Comments from the Georgian Society

Offa House, Village Street, Offchurch, Warwickshire

Dear David,

Revision	Drawn
Project	GA / RP
Proposed Development at: Offa House, Offchurch Village St, Offchurch, Leamington Spa CV33 9AS	Date 05/08/2021
Client	Scale(s) @ A2 1:100
Joe and Louise Hartog	Status Sketch
Sheet Title	Project No. 107:20
Proposed Barn Elevations	Rev B
	Dwg No. 10721-HBA-DR-A-020

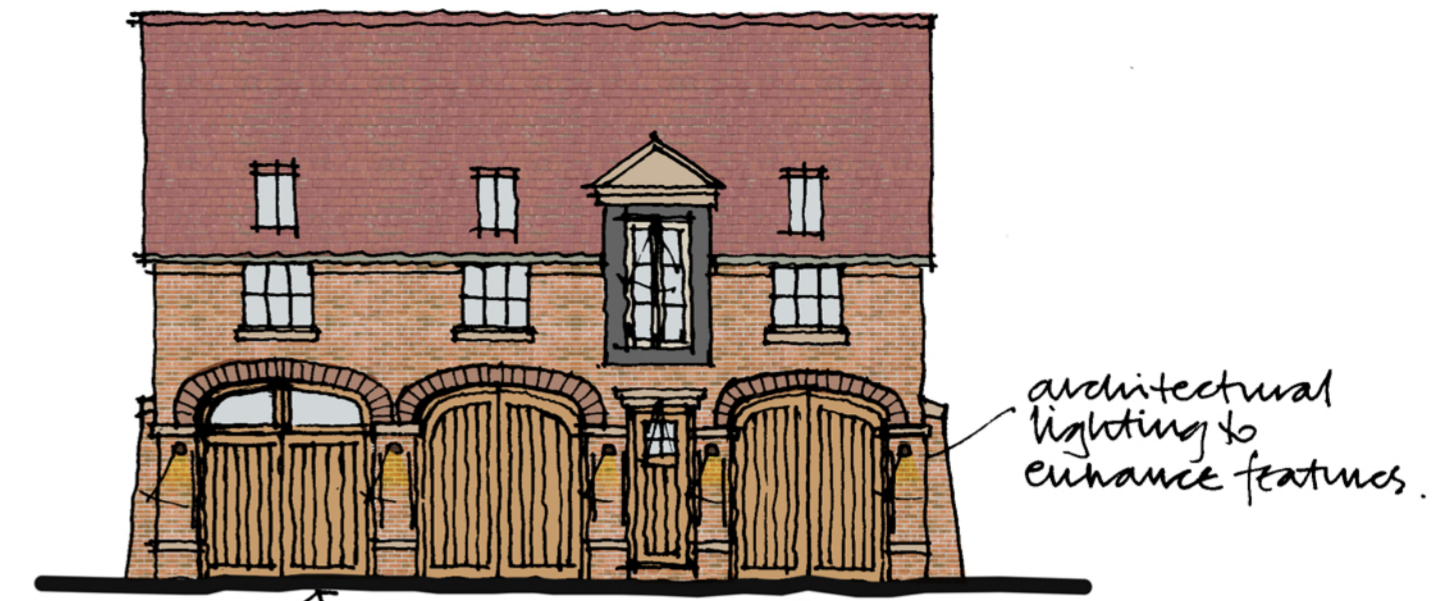
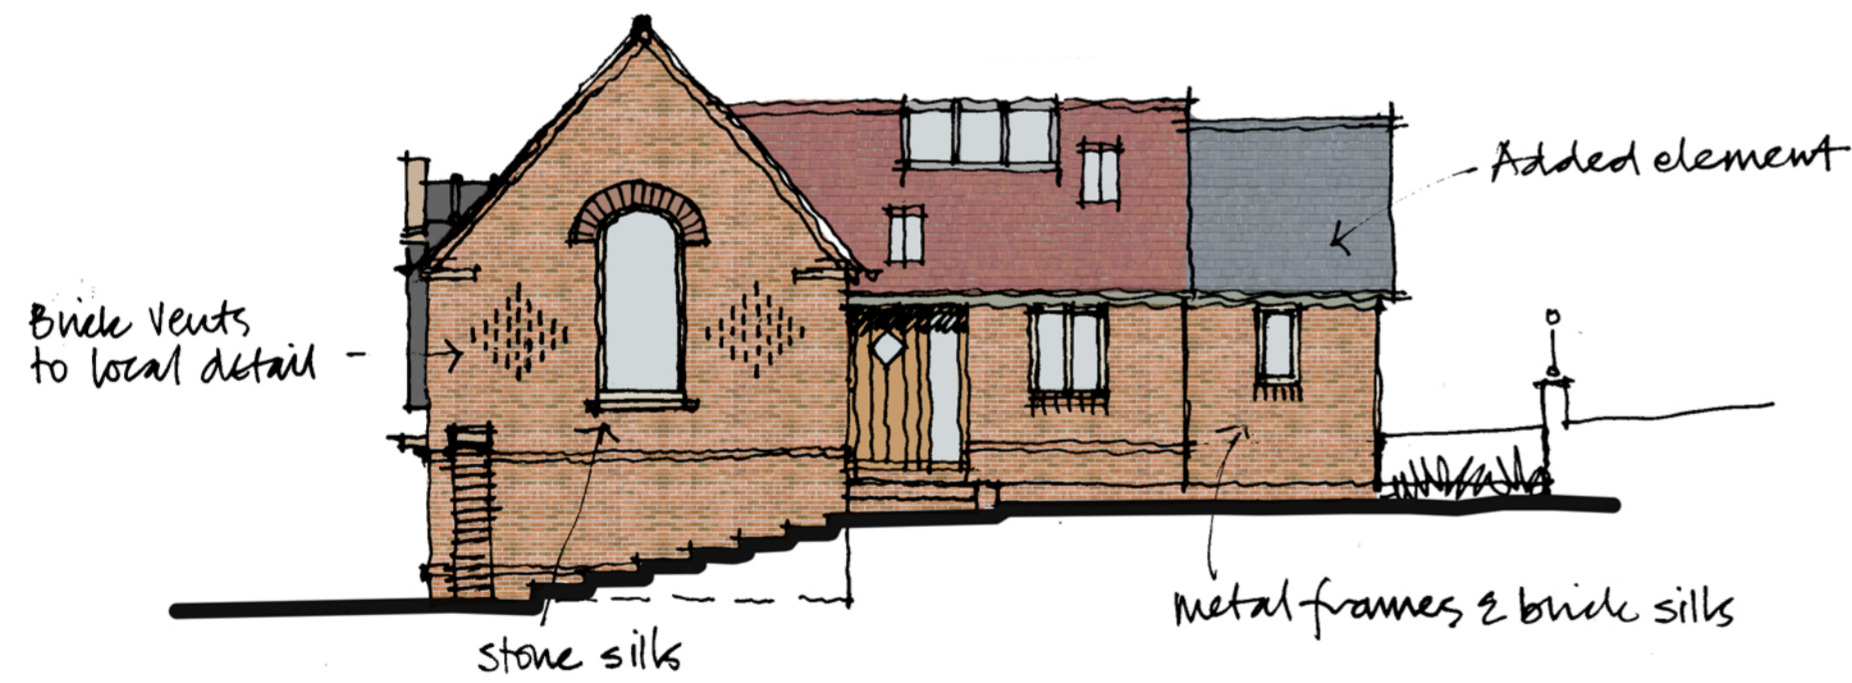
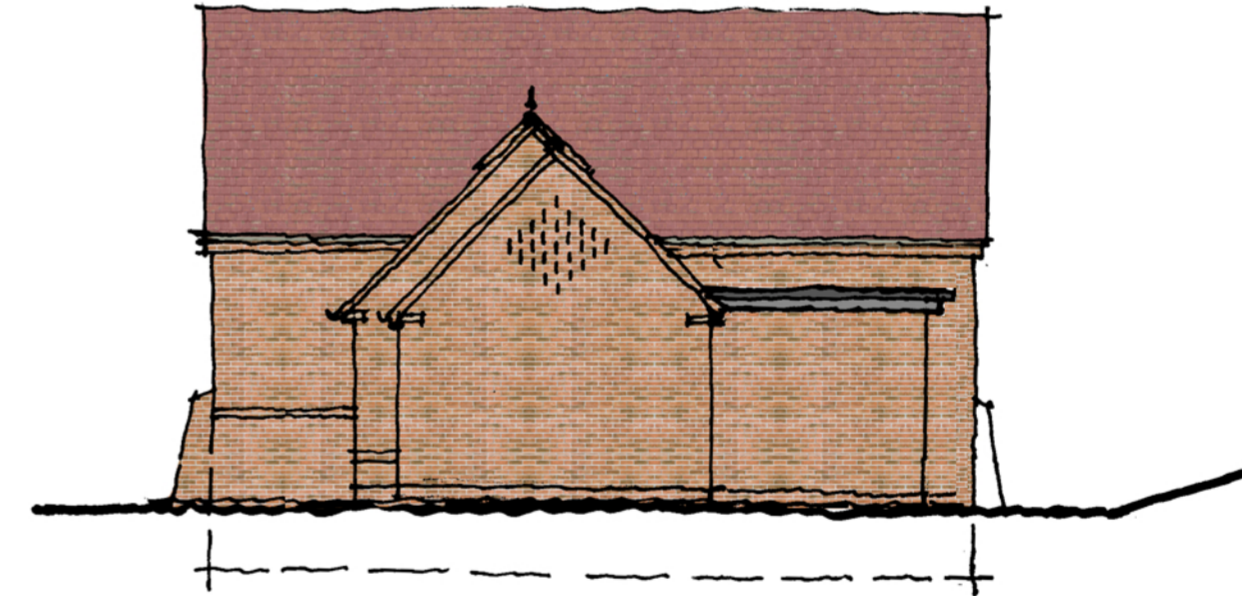
Concern was also raised by members over the design of the elevations of the proposed new kitchen wing which they concluded were of an overly assertive nature. Members stressed that the design of any proposed new addition should respect the historic hierarchy of the house's elevations in its materials and detailing. The elevation on which the proposed addition would be built was not designed for display and therefore was of a far more restrained design than either the 1806 garden façade, or the early eighteenth-century entrance range. Members also stressed that any new addition of the size proposed would need to be carefully justified as there may arguably potentially be space available within the existing fabric for a reasonably sized family kitchen.

There are two areas of the proposals as they relate to the main house however, which may need further consideration. The external treatment of the proposed new kitchen wing was a particular issue for members largely due to its adoption of formal classical detailing for an addition to one of the house's service façades. [A] A more restrained and less rigidly formal approach to the design of this wing would be welcomed, whilst the requirement for a new addition of the size proposed would also need careful justification. [B] Members also had some reservations regarding the potential impact of the proposed remodeling of the staircase hall on the special interest of the listed building, advising that an intervention of this scale and ambition would need further careful and detailed justification. If you would like further clarification of any of the issues raised in this email, I would be happy to discuss these issues with you. I must emphasize however that we regard the two areas of the scheme where we have some concerns as matters of detail and that we are largely happy with these proposals.

Note: Following the above comments the issues [A] and [B] have been carefully addressed. The kitchen extension has been redesigned; and, the staircase (existing C20) has been covered in more detail in this report.

Revision	Drawn
Project	RP / GA
Proposed Development at: Offa House, Offchurch Village St, Offchurch, Leamington Spa CV33 9AS	Scale(s) @ A1
Date	14/07/2021
Client	1:100
Joe and Louise Hartog	Status
Sheet Title	Sketch
Offa House: Proposed Plans	Project No.
	107:21
	Rev
	A
	Dwg No.
	10721-HBA-DR-A-018

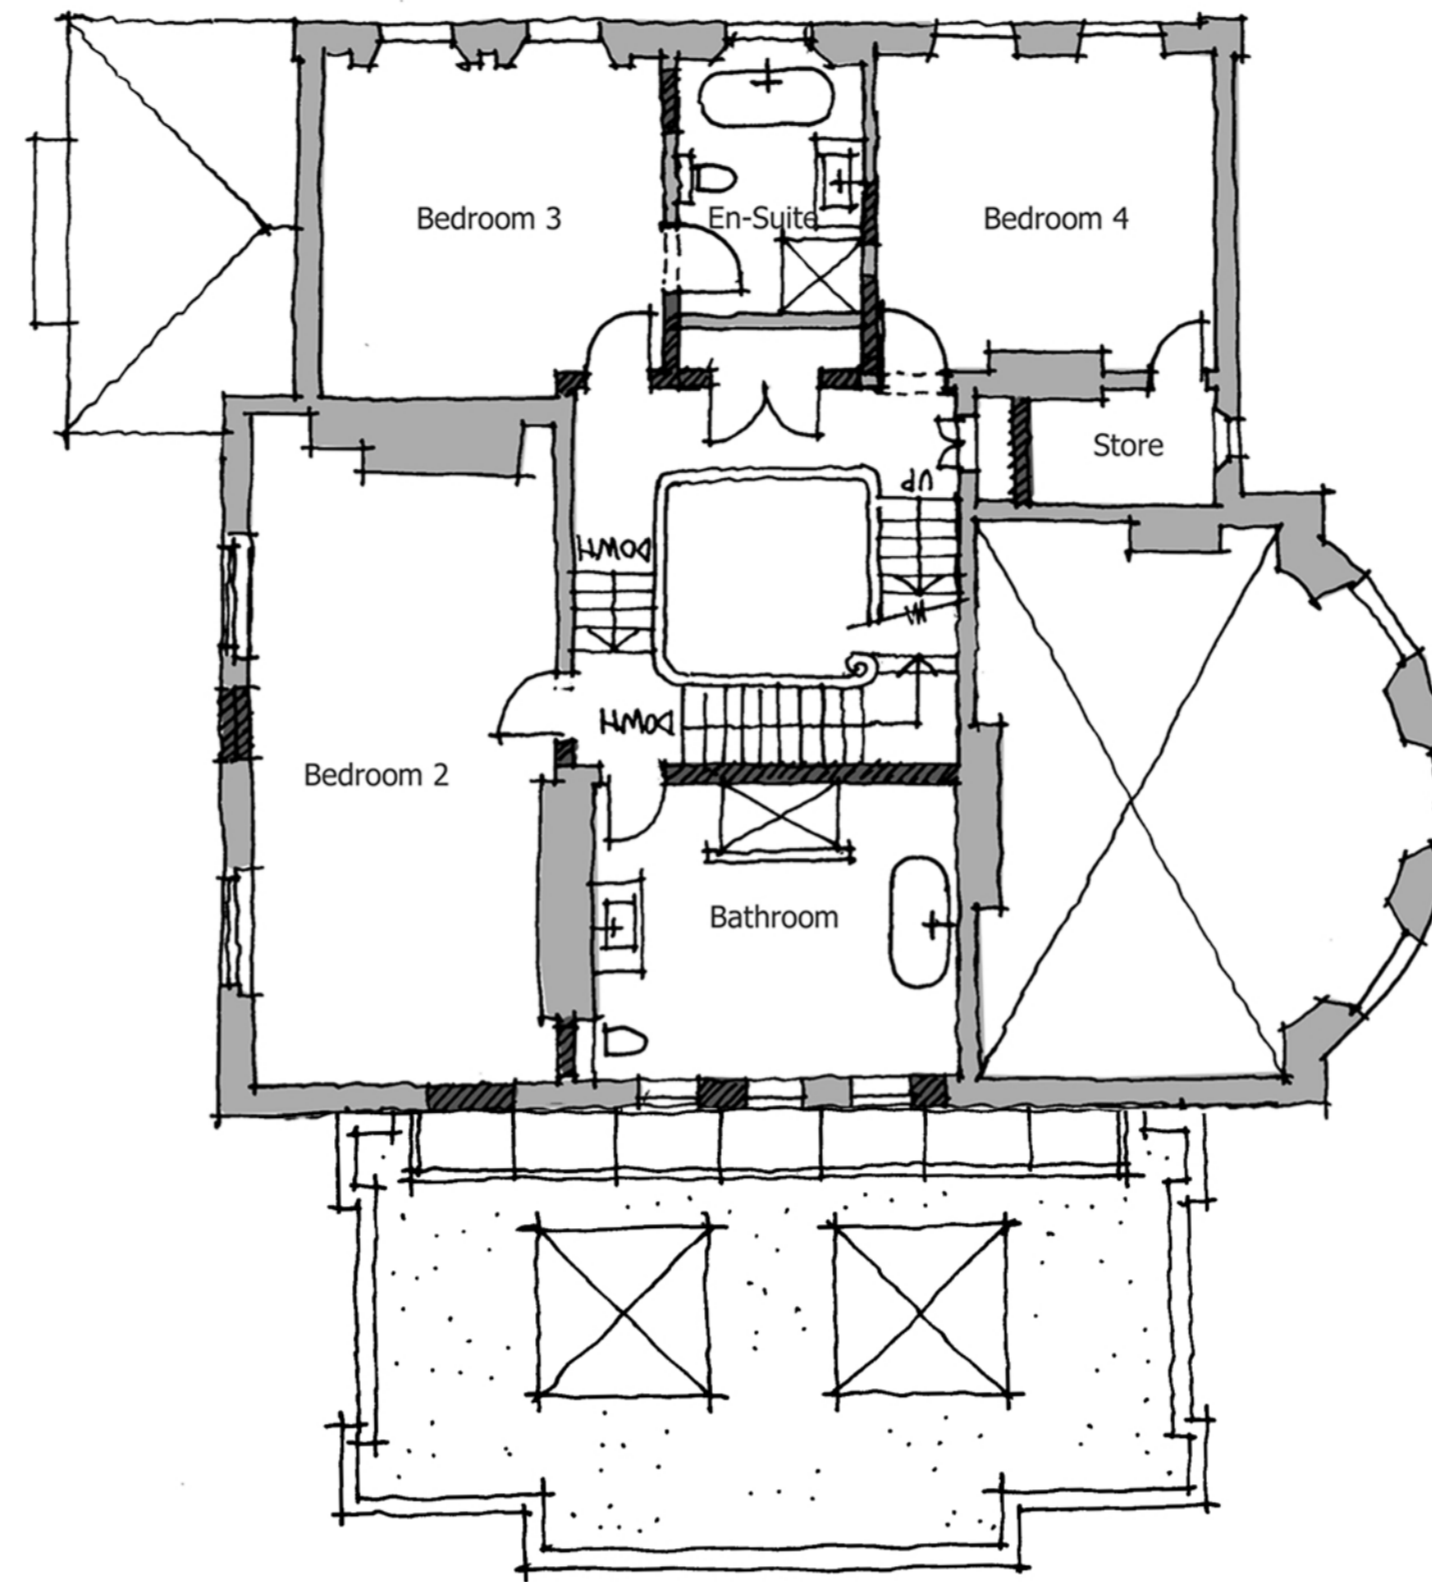
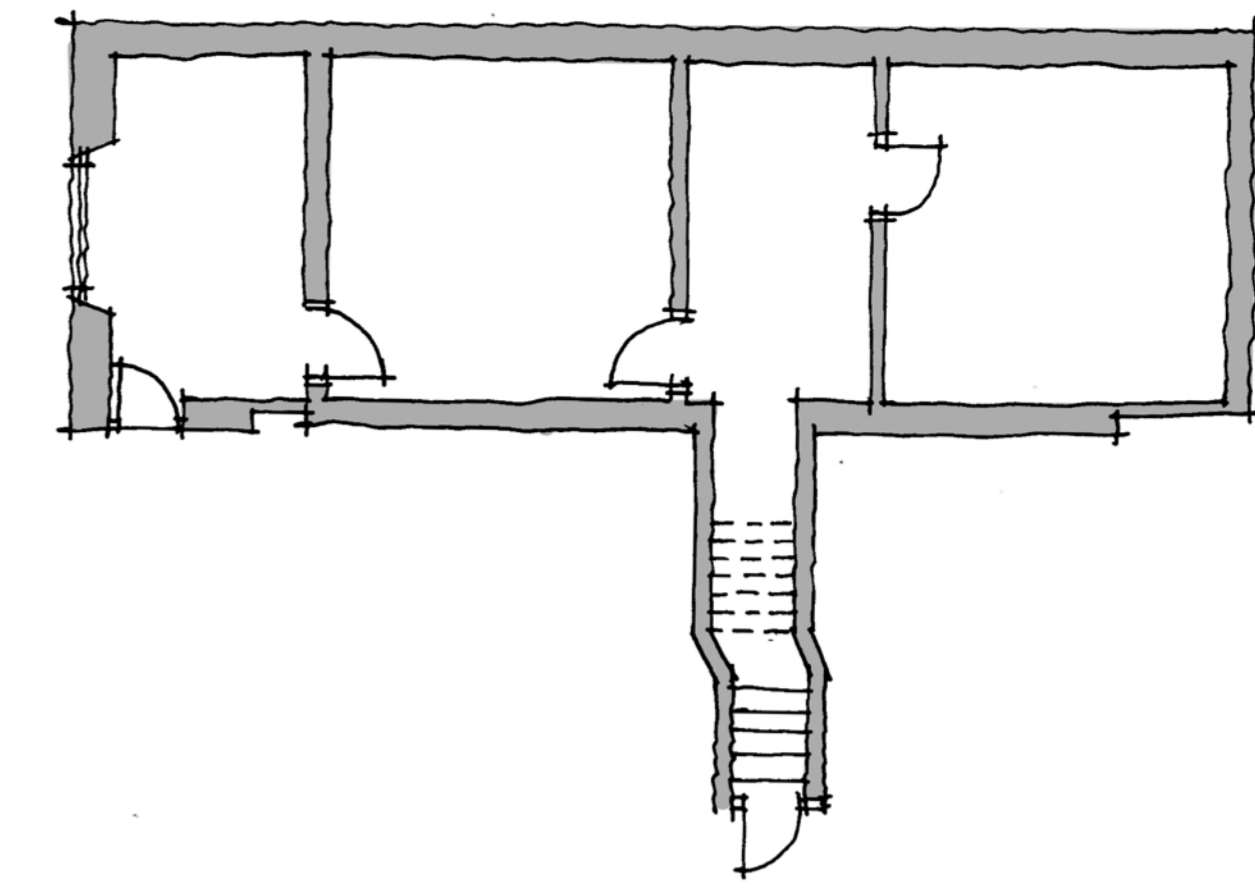
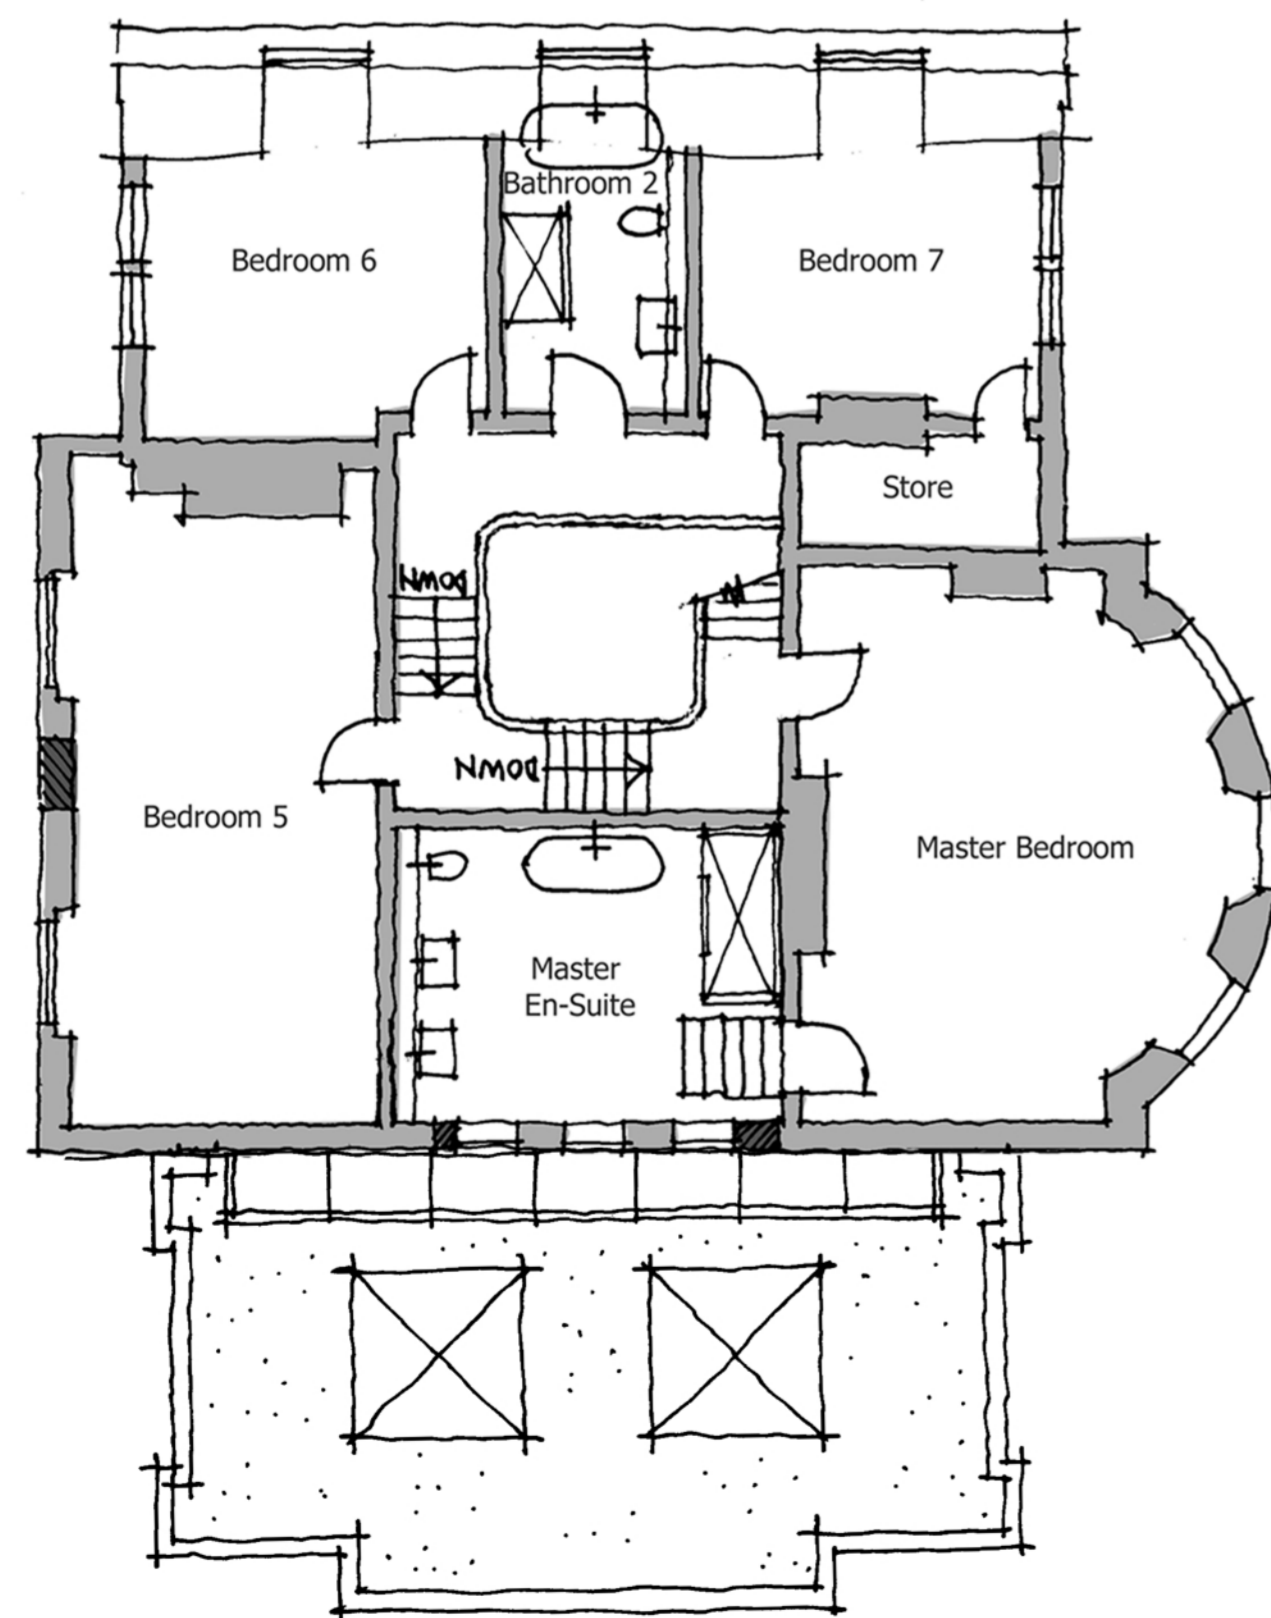
It is clear from the documentary evidence you have found and from an inspection of the house, that its building history is a far more complex one than the present listing description suggests. It is also clear that much of the significance of the interior has been lost due to later twentieth century internal alterations of a highly unsympathetic nature. Only one small section of the c1806 principal staircase survives, and this has been subject to a high level of unsympathetic repairs. Whilst the Committee had no objection in principle to many of the alterations proposed, a number of its members did express some concern about the size and grandeur of the proposed new top lit staircase hall and the potential impact of this element of the scheme on the surviving elements of the historic plan form of the 1806 range.
